From
 The Member Secretary,
 Madras Metropolitan
 Development Authority,
 Thalamuthu-Natarajan Building,
 No.8, Gandhi Irwin Road,
 MADRAS: 600 008

Lr.No.D.Dis. A/8355/85. dated 4-12-85.

Sub: MMDA - Planning permission - ^{Additional} Construction of residential building in Plot No. 2, E.R. Ramakrishna village - Approval - Regarding ^{of Virugambakkam}

SECTION ON: AB

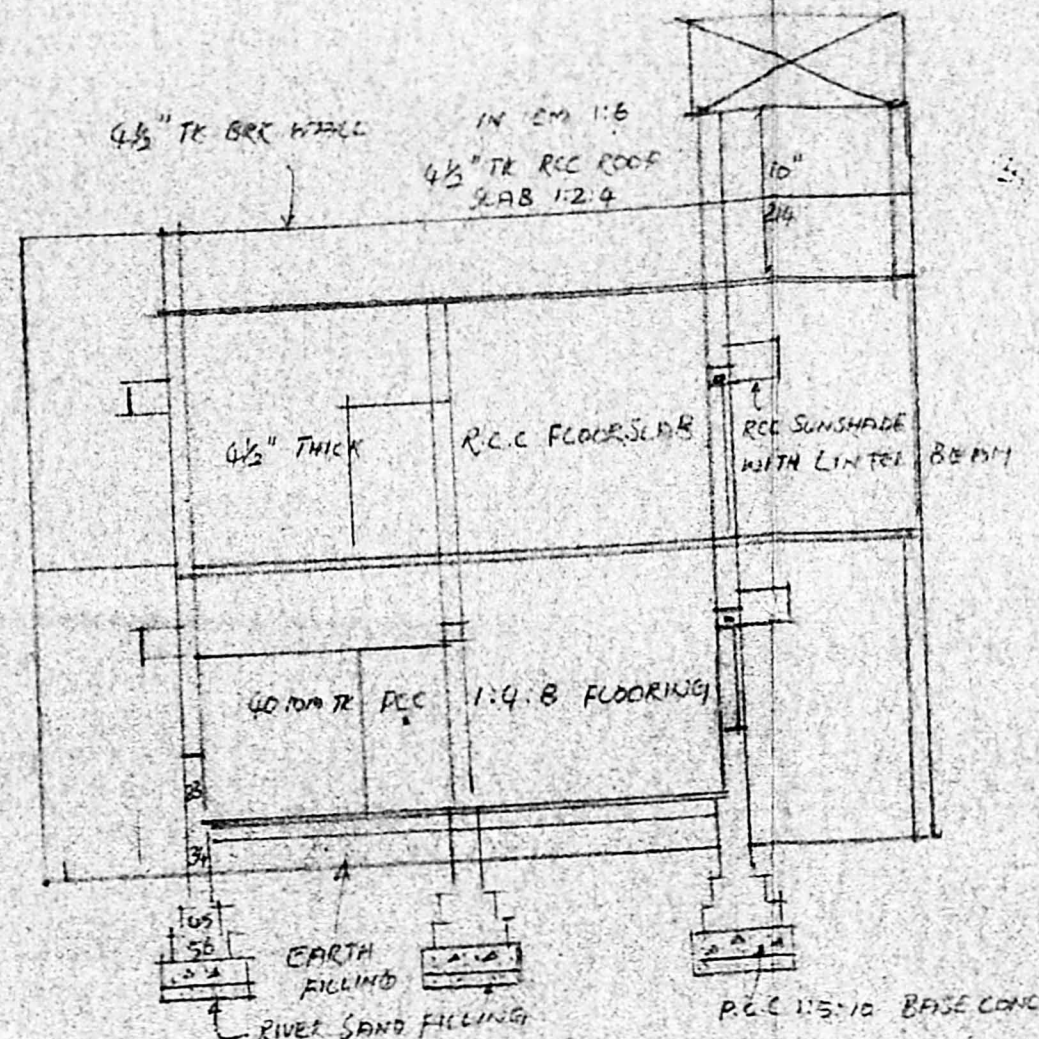
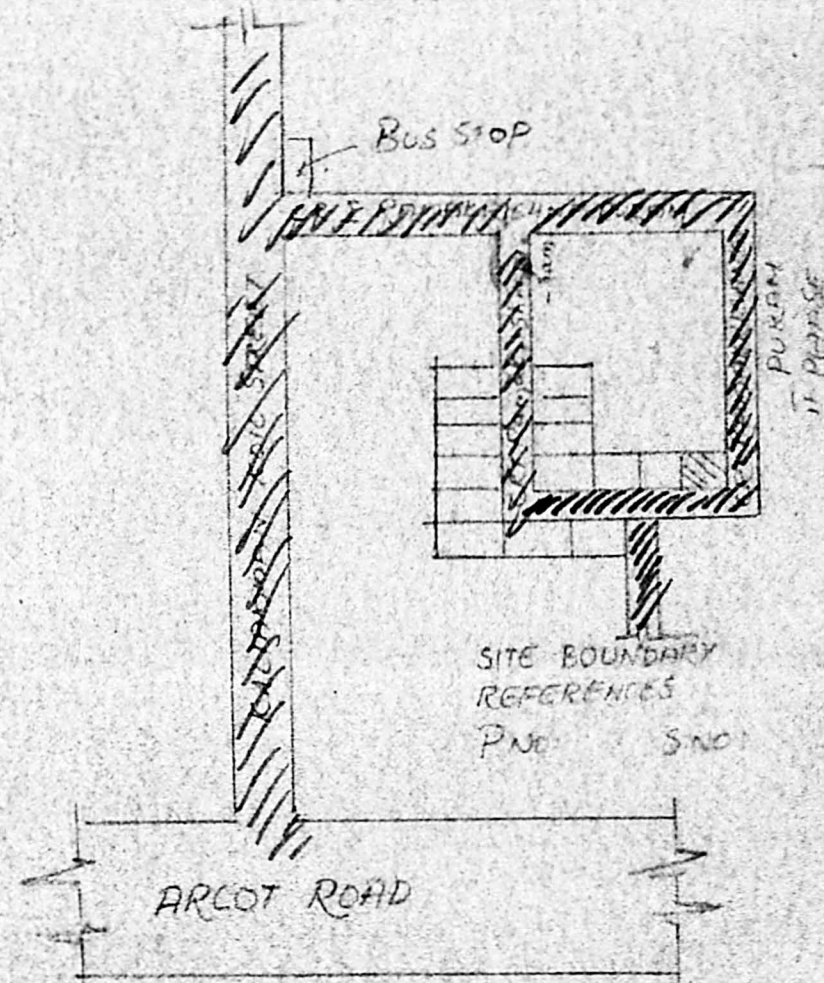
iii) 'it was requested to ensure that the plans for the new buildings will incorporate the approved designs for mosquito-proof overhead tanks and wells'

SITE PLAN/GROUND FLOOR PLAN

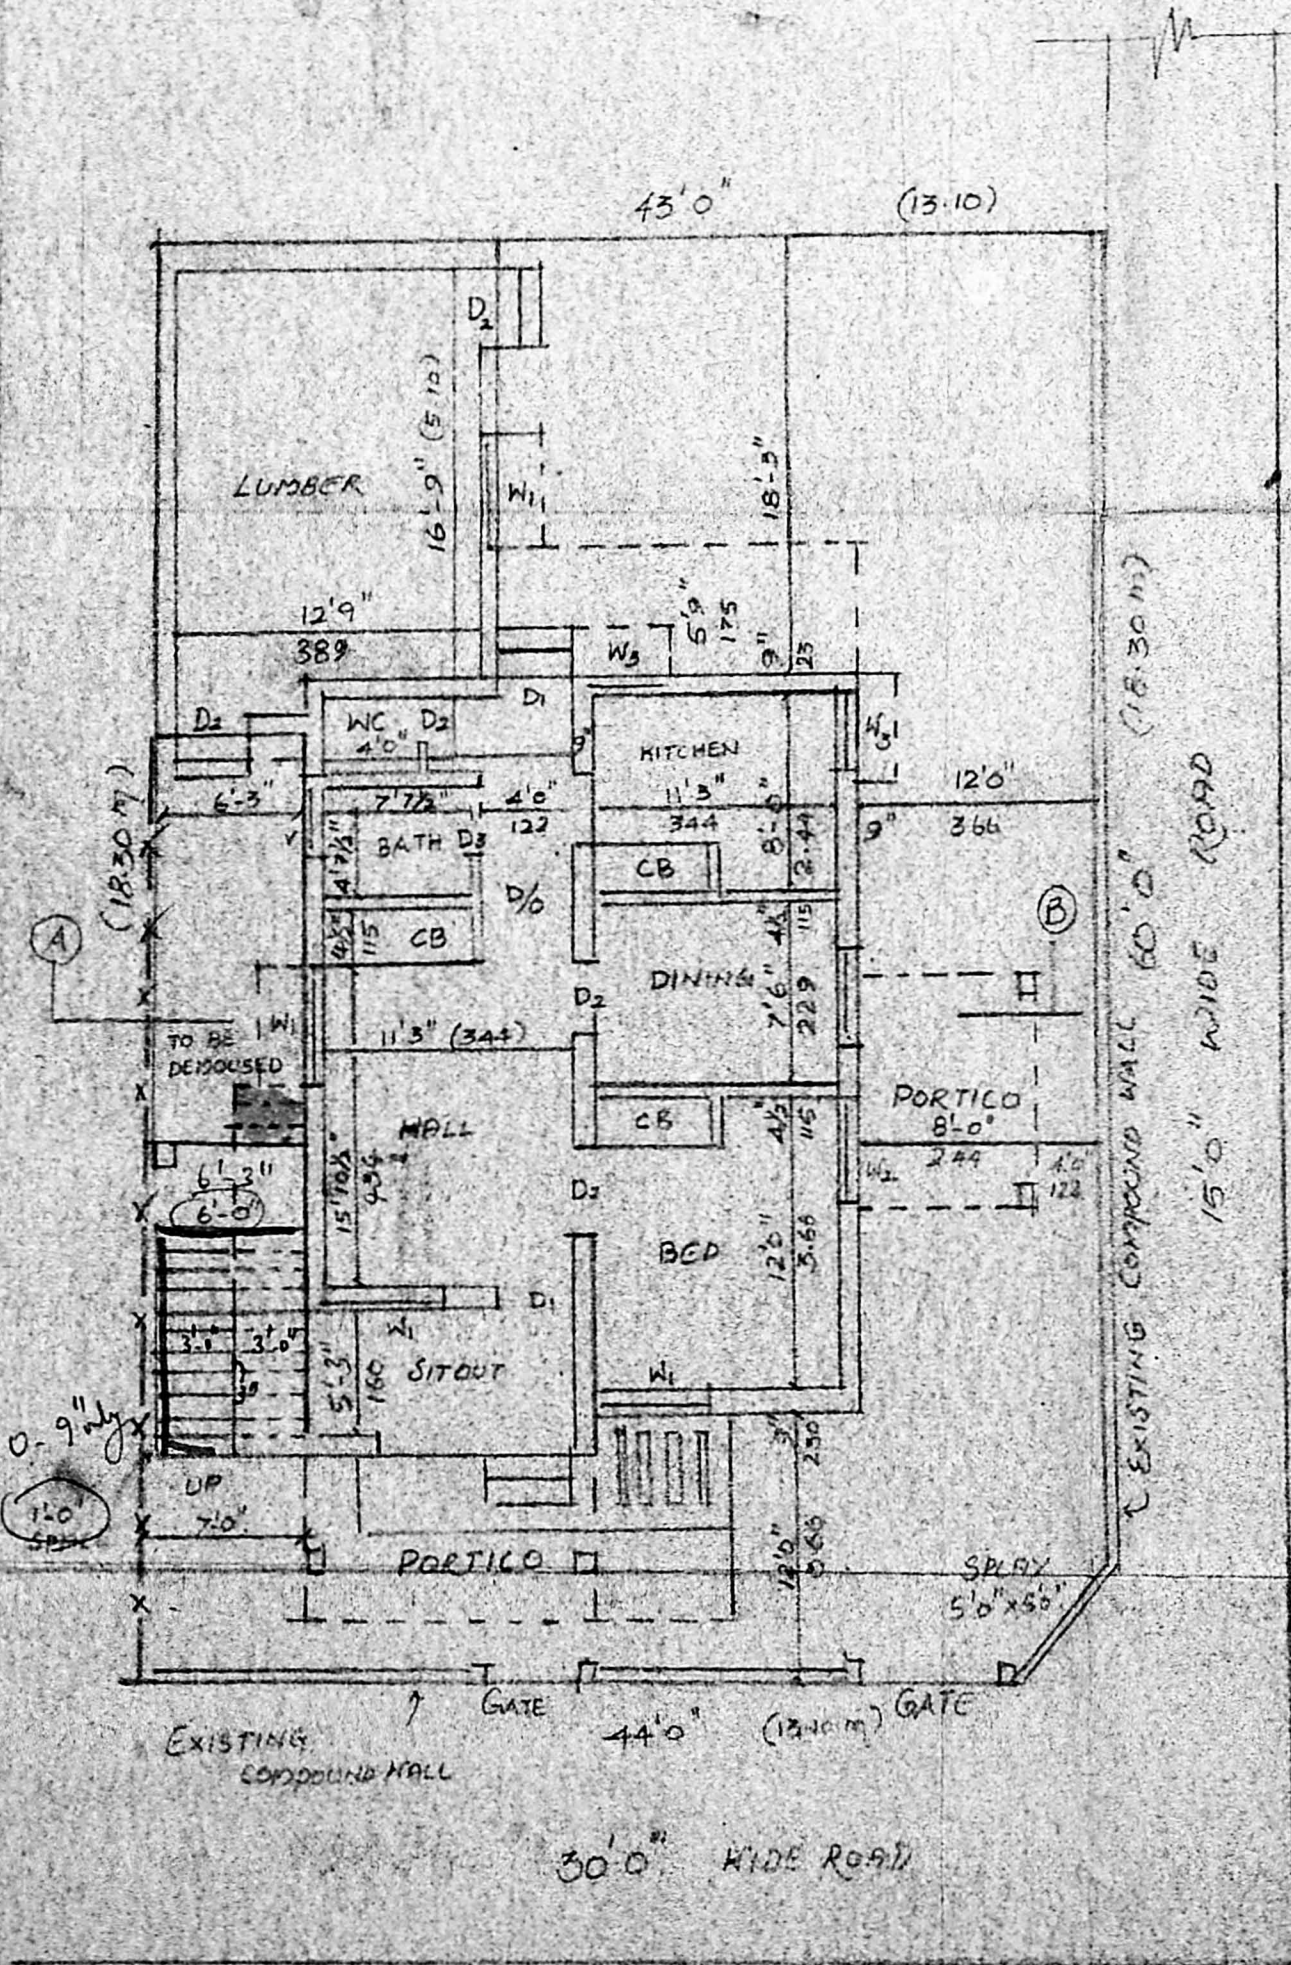
(i) The applicant should remove the reinforcement projected up to 7 feet in the western boundary of the site.

The approved plans are numbered as Planning permit No. A/1281/85 and ~~two~~ copies/sets of the same along with two copies of the planning permit are enclosed herewith for taking further action in this regard. You are requested to issue Building Permit only after ^{ascertaining whether the reinforcement put up above ground floor on the western boundary line are removed.} Yours faithfully,
